Re: Objection to Amended Planning Application: R/64/17/PL

Location: St Mary's Close, Hurst Road, Rustington, BN16 3AP

We are responding to the amended plans for this development by MJH Homes. In our view this new proposal changes very little & most of our original comments in our letter dated 12<sup>th</sup> May remain valid.

Drg No: 151117_SS-01 Rev: D

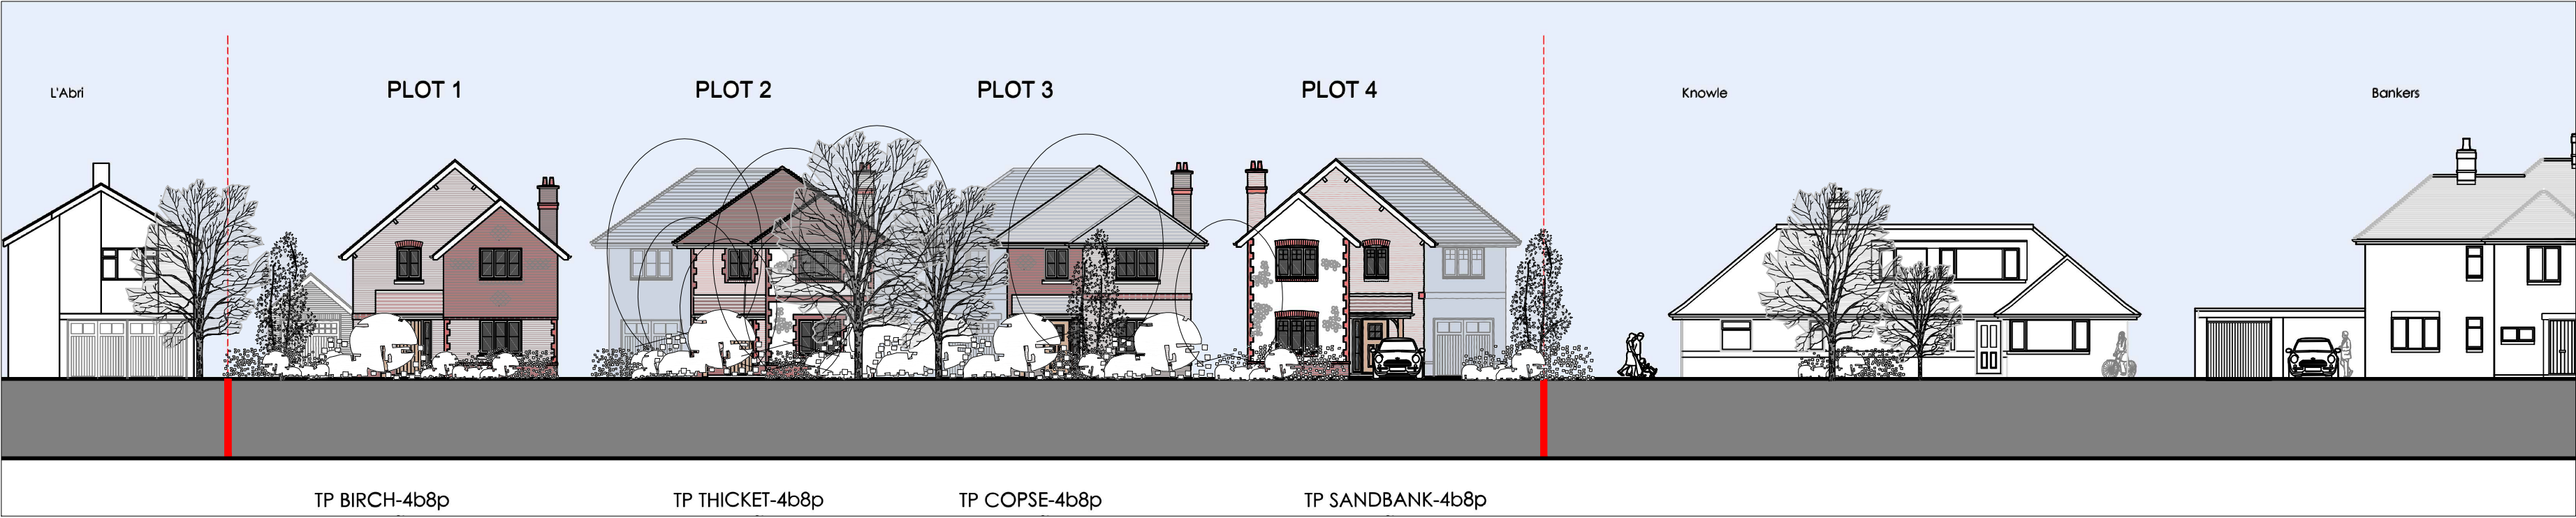
- 3) **Design & visual impact** – The proposals are for two slightly different designs and the developer has attempted to make them look different by using various cladding materials. Further detail has been provided in the amendment, however our objection remains - that as seen from the elevation plans this is just superficial, they still look very similar (MJH Substitute Street Scene Drawing). They do not fit with the individual properties in Hurst Road and the proposed development will spoil its appearance and character. In fact the proposed scheme contravenes the Local Plan - D SP1 Design as it does *not* "Respect, improve and enhance the existing surrounding environment".
